BCA ASSESSMENT REPORT

Lots 33-35 & 43 Yarrunga Street, Prestons

Client: Logos Property Group

Revision 3

SITE PLAN - COLOURED OVERALL ESTATE PLAN

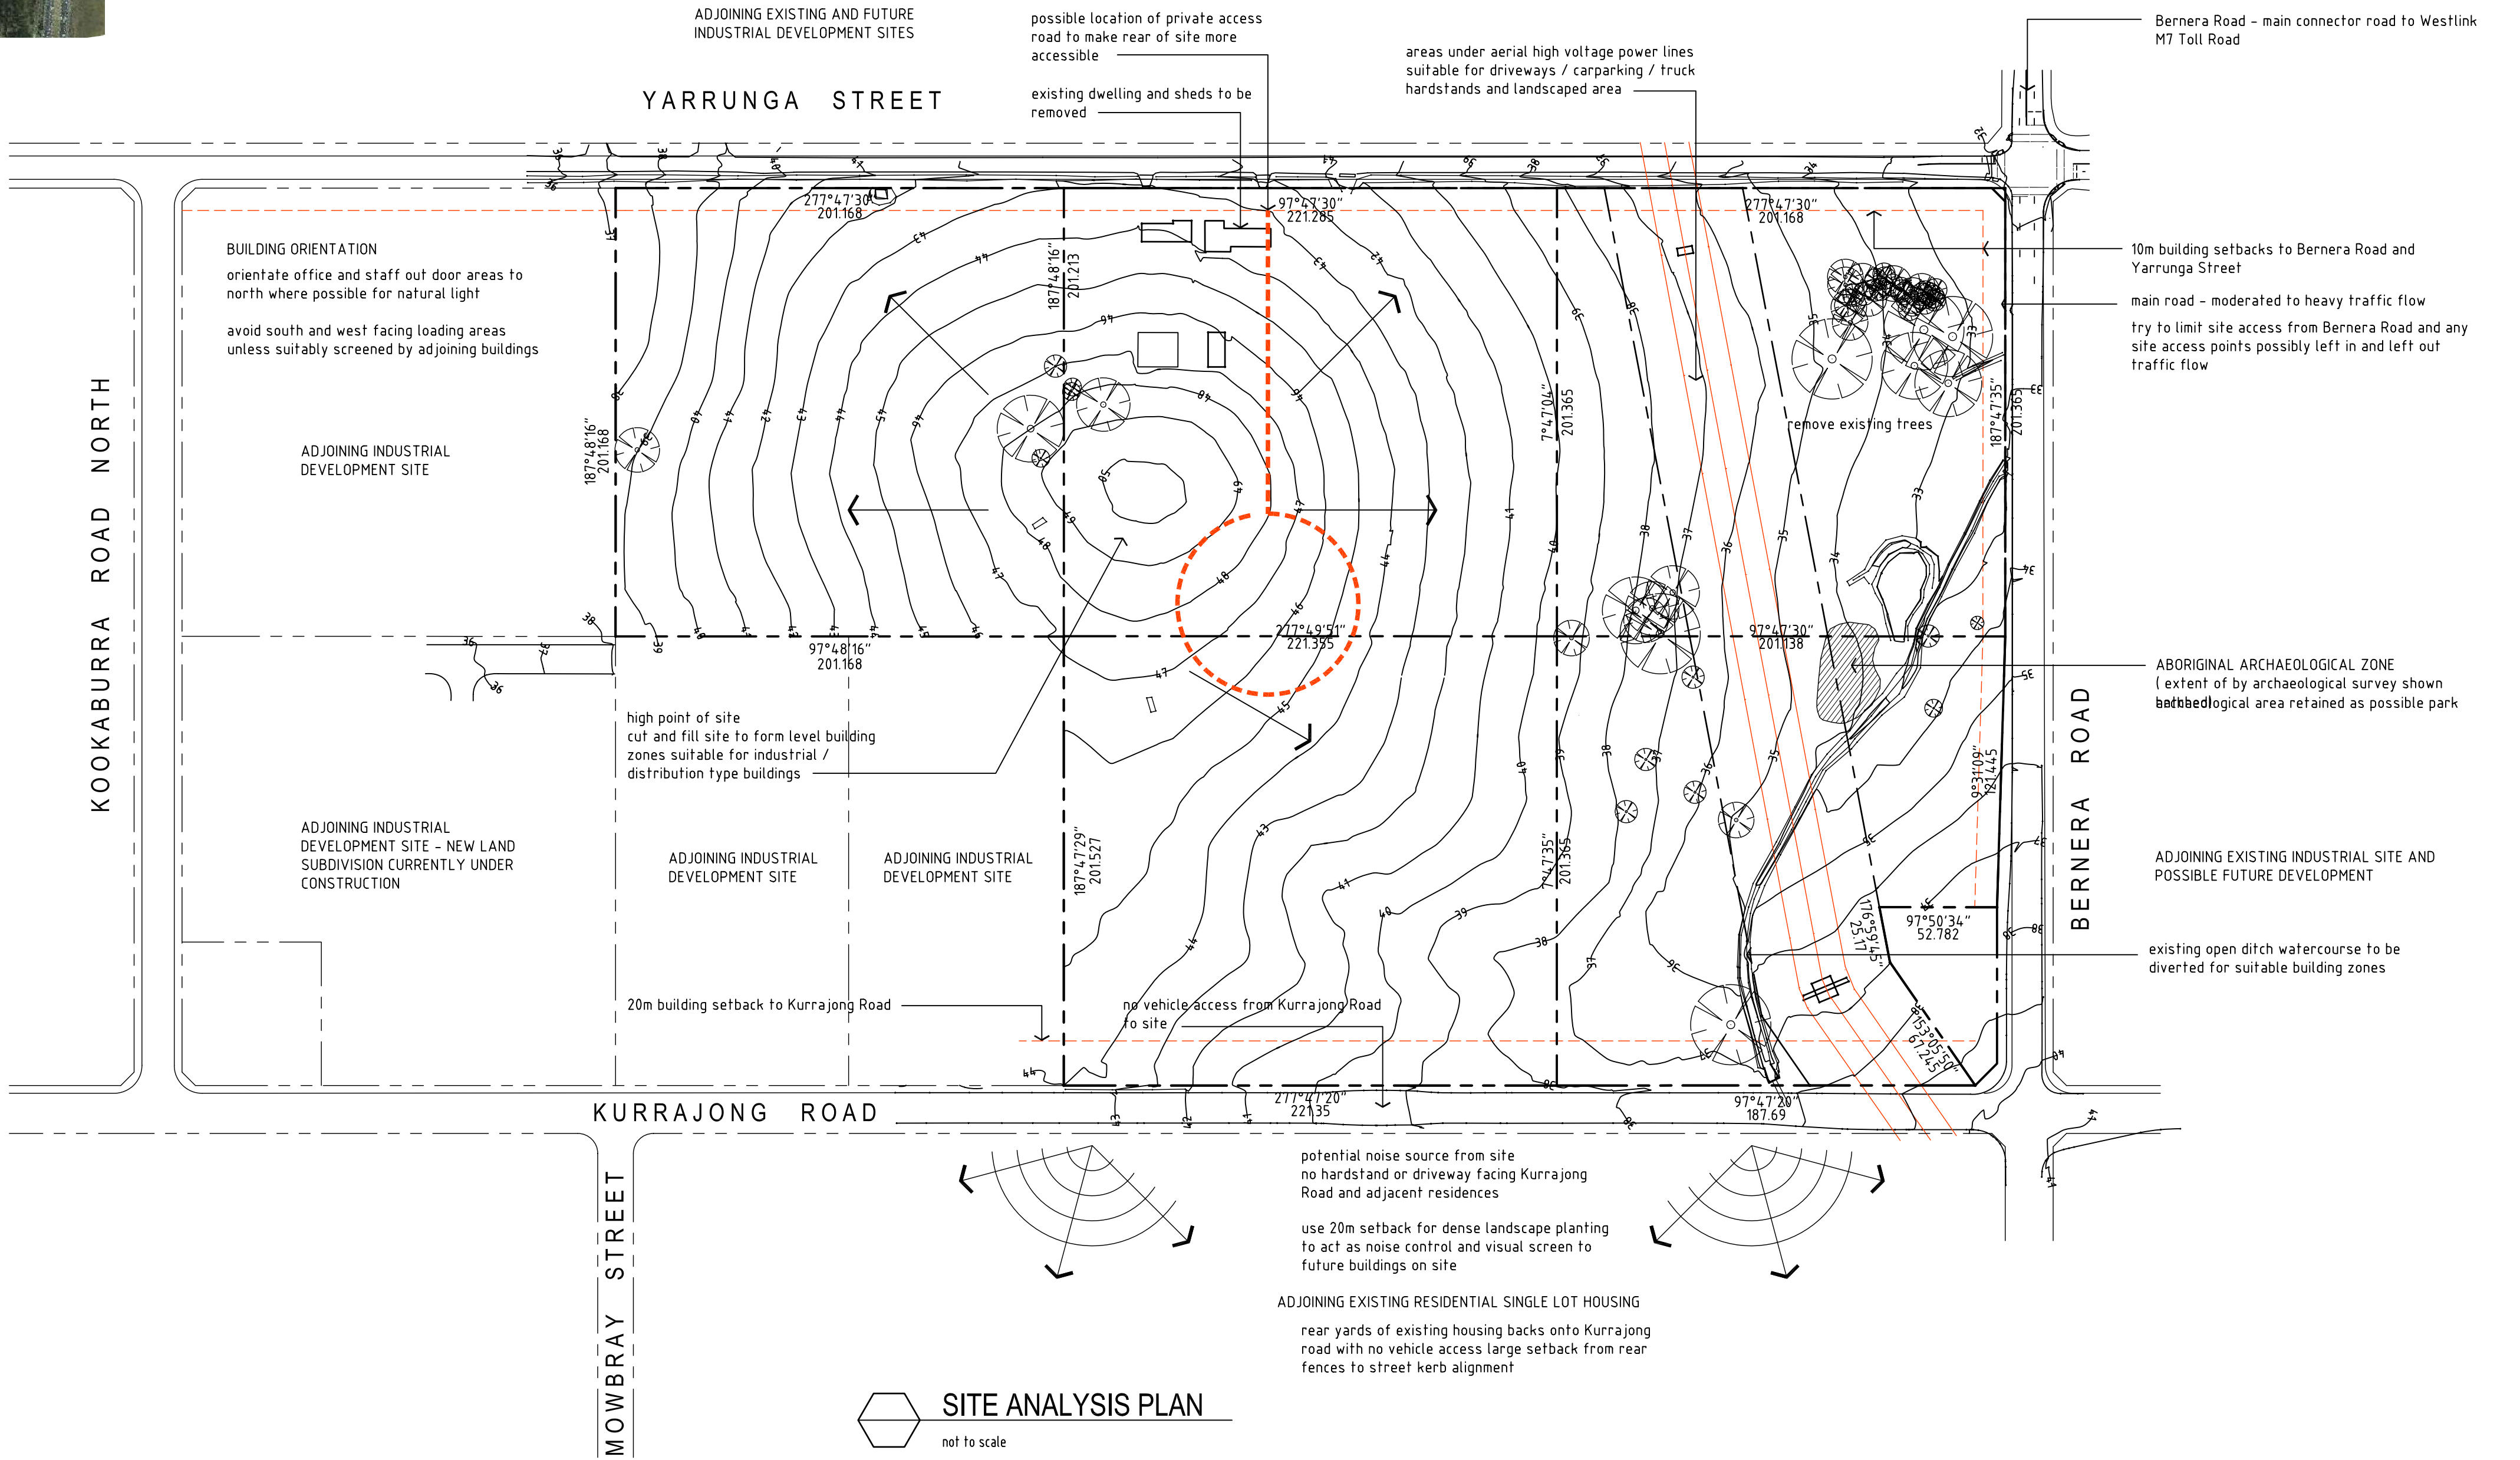
Comments: The proposed warehouse buildings do not comply with the provisions of C2.4 and thus the following non-compliance issues are required to be addressed as an alternative solution by the Fire Safety Engineer to demonstrate compliance with Performance Requirement CP9 - refer to the dot points and the diagram below for details of the proposed non-compliance issues:

- Vehicular Access is discontinuous between Warehouses 2, 4 & 5;- refer to diagram below.
- Vehicular Access is located greater than 18m from the external wall of the buildings in a number of locations around the site as indicated below.
